March 5, 2024

The plan and truss documents were reviewed for lot #44 Tobacco Road subdivision in Angier, North Carolina to address several damaged trusses in the second floor system noted by the inspector. Analysis revealed the following:

MODEL: HICKORY D - FLOOR

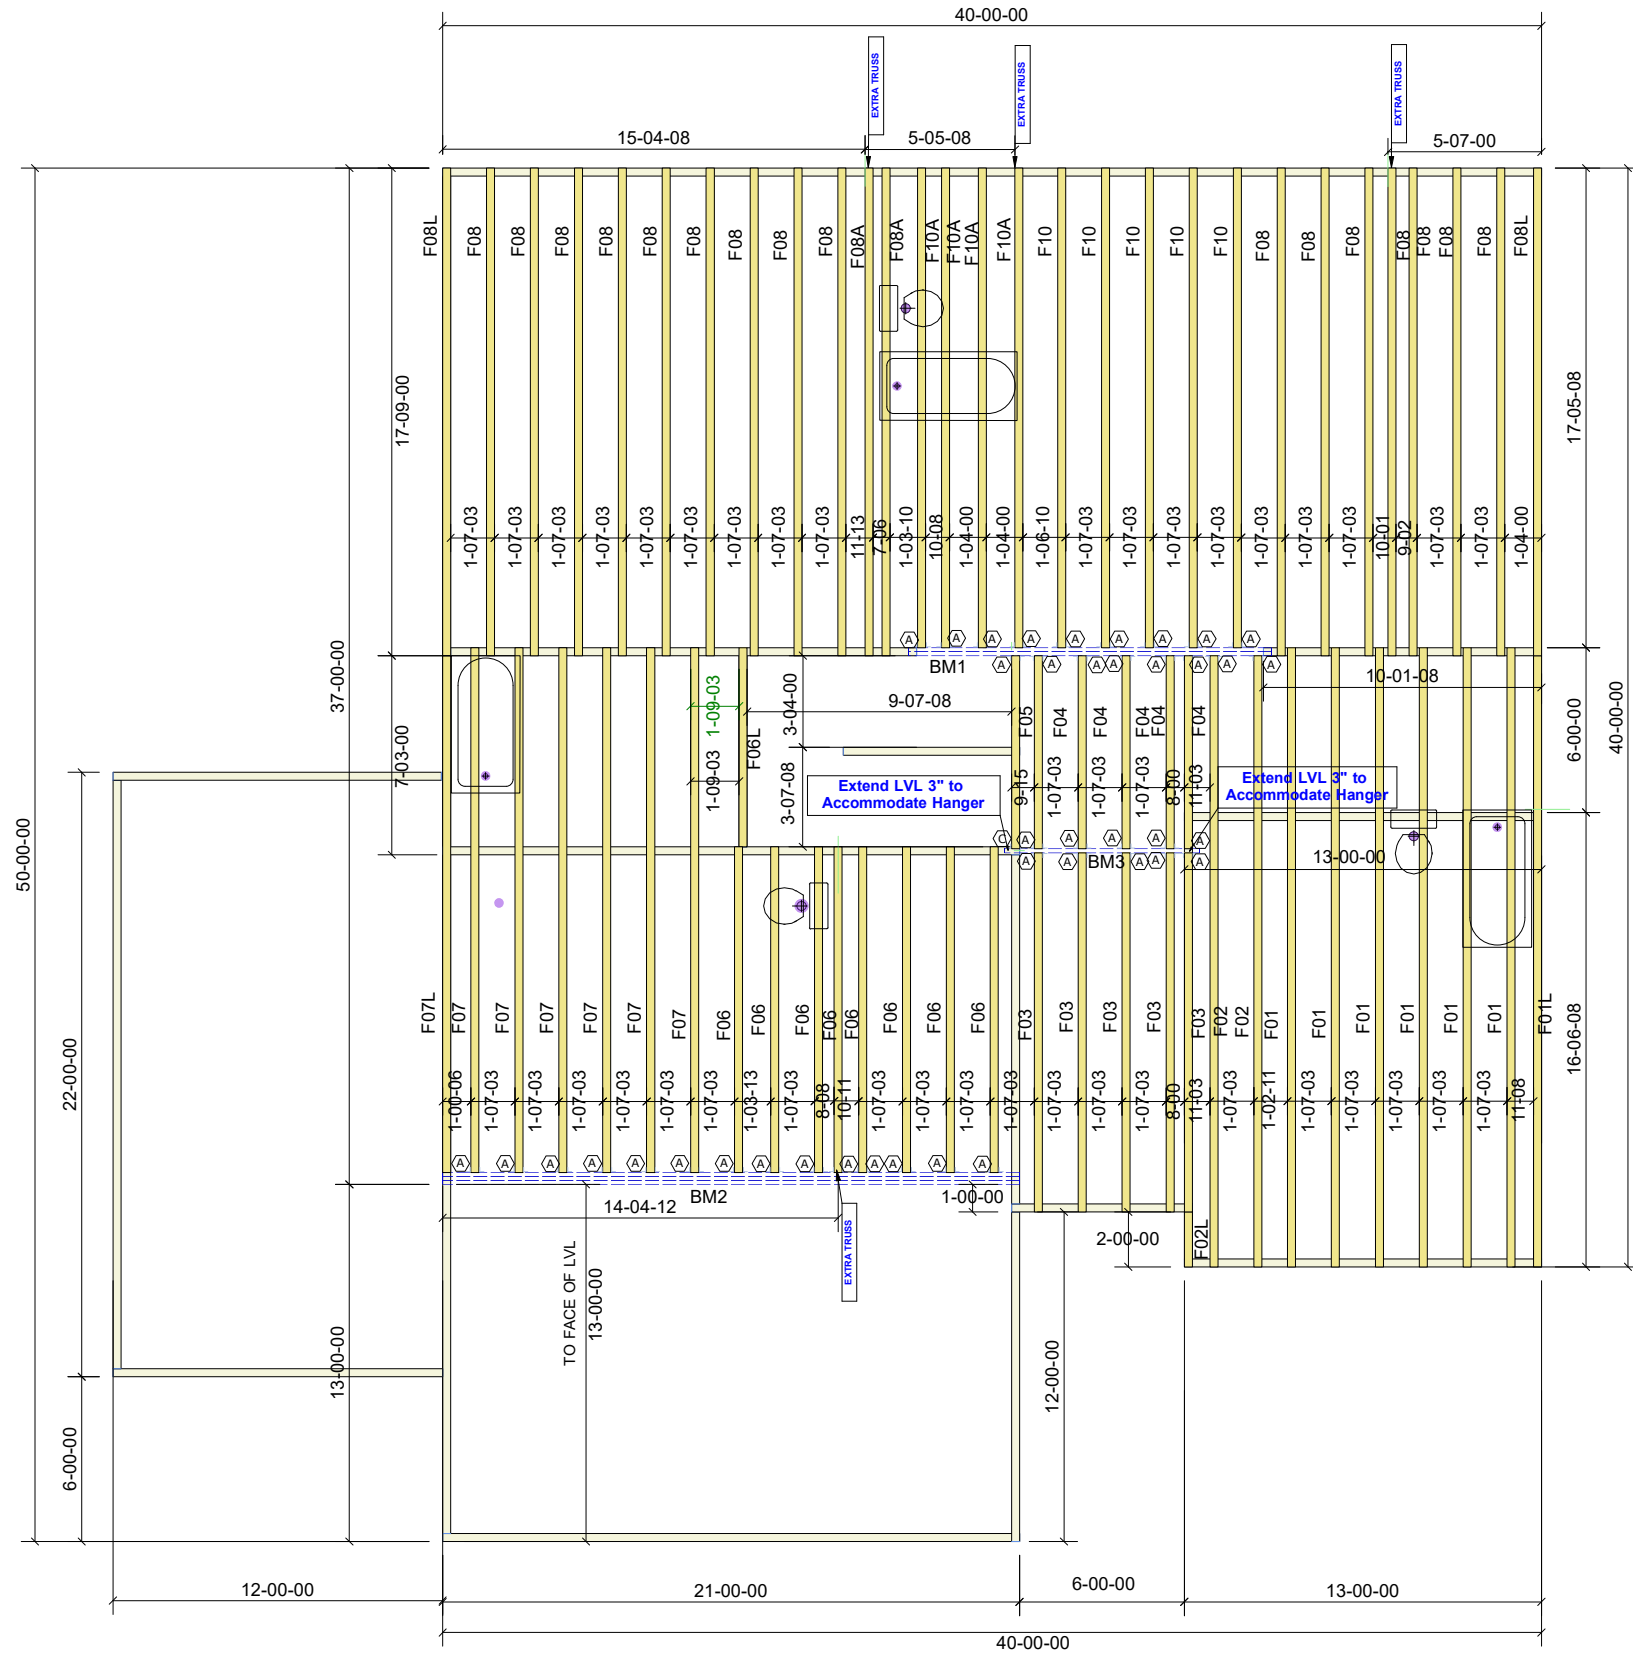
- 1) The F01 truss with a damaged gusset plate at point 12 requires a 24" x 14" x 3/4" OSB gusset fastened from the end with construction adhesive and (1) row of 8d nails at 4" o.c. in all members.
- 2) The F01 truss with a hole drilled in member 11-12 for a wire requires a 2 x 4 x 6'-0" SPF #2 scab fastened from the end with (1) row of 12d nails at 4" o.c.
- 3) The F01 truss with a damaged gusset plate at point 9 and broken member at point 8 requires a 24" x 14" x 3/4" OSB gusset centered at point 9 fastened with construction adhesive and (1) row of 8d nails at 4" o.c. in all members. A 2 x 4 x 6'-0" SPF #2 scab is to be fastened from point 9 past the damaged area with (1) row of 12d nails at 4" o.c. The member is to be furred out with OSB prior to installing the scab.

This configuration will provide the required support for all applied loads.
